**North Somerset Council Planning Department**

**Date: 21/12/23**  
**My Ref: 1782/23/02**

**Site:** Ruslin Farm, Rusling Lane, Butcombe, North Somerset, BS40 7XQ  
**Description:** Application for Variation of a Condition following Grant of Planning Permission  
**Portal Ref:** PP-12691704

Applicant: Mr G Aldridge
 Project: Proposed New Dwelling
 Address: Ruslin Farm, Butcombe, Bristol BS40 7XQ
 Date: November 2021
 Drawing No: 2021-B/ALDRIDGE/05

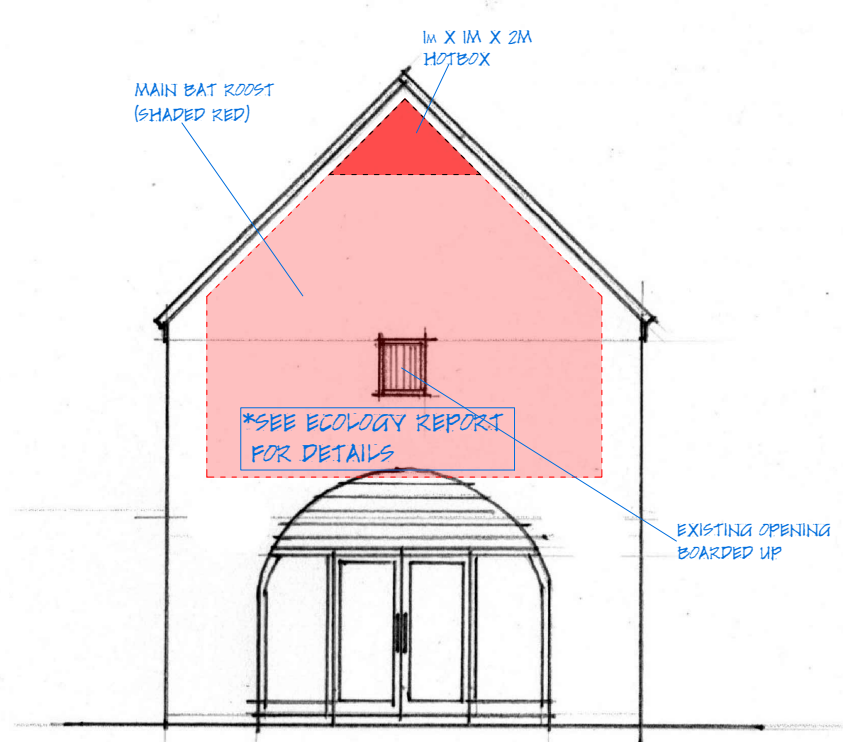
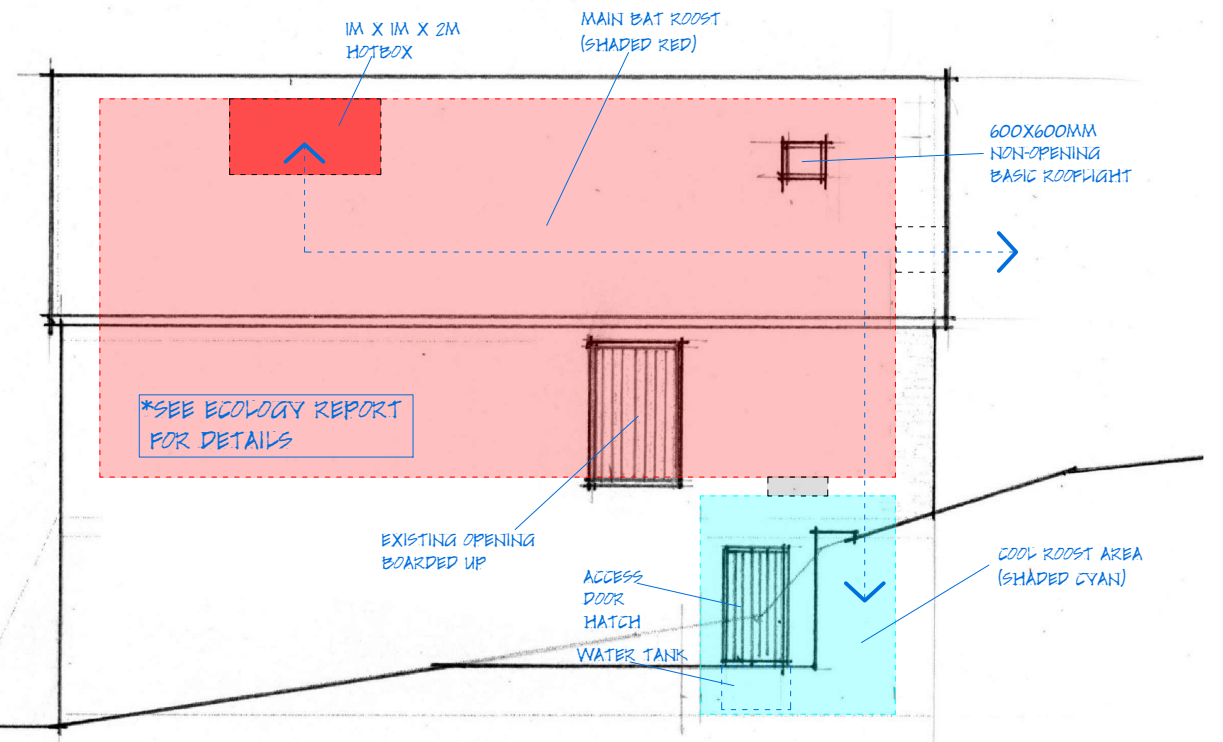
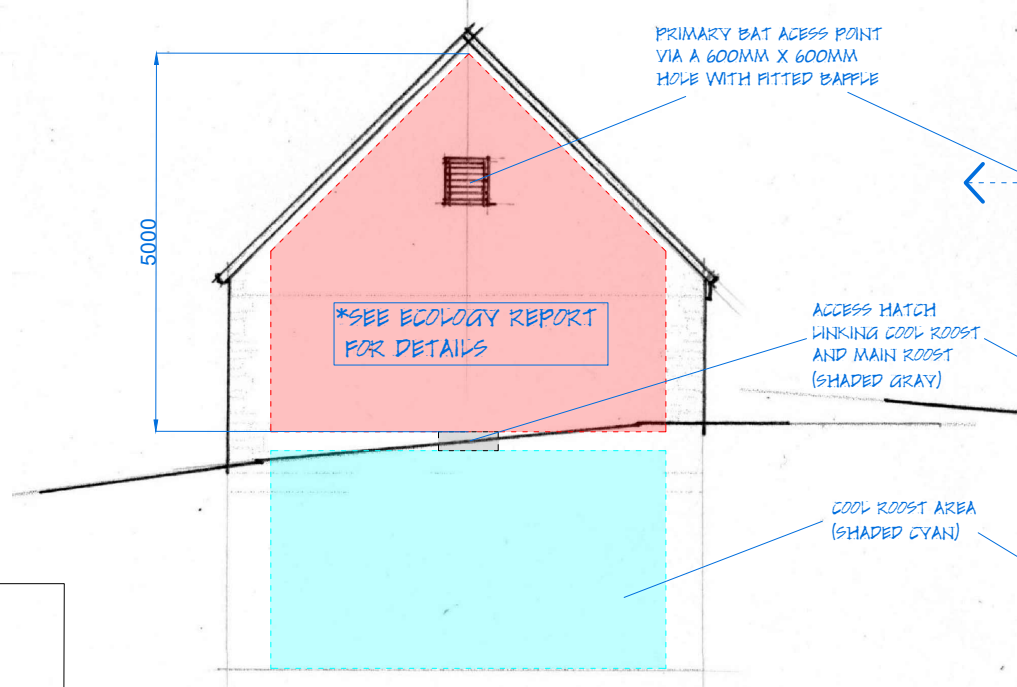
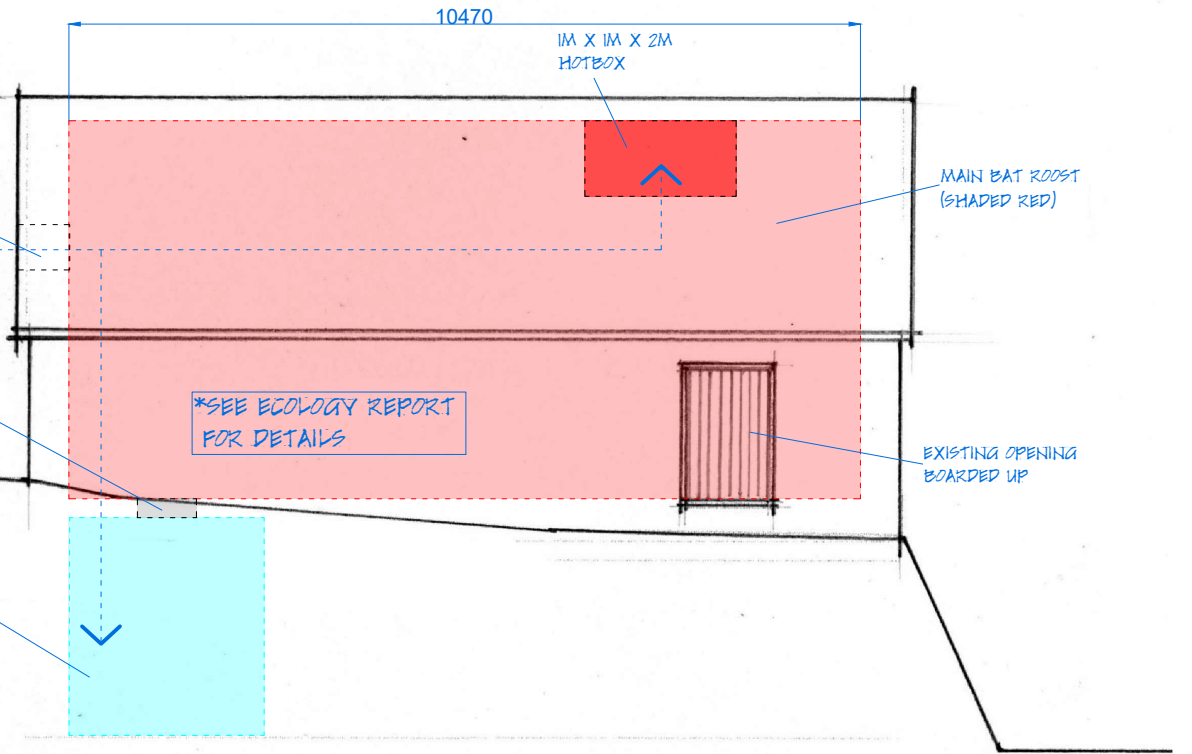
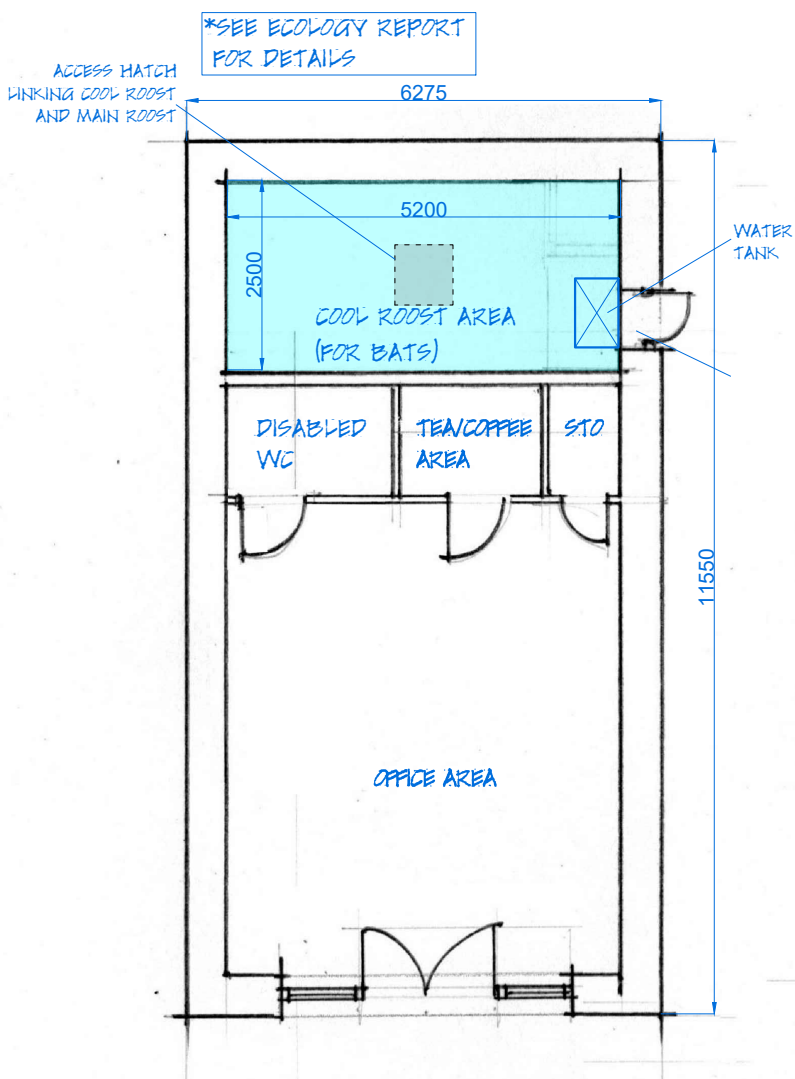
*Drawing no. 2021-B/ALDRIDGE/05: Proposed floor plan and elevations for annex office and bat roost*
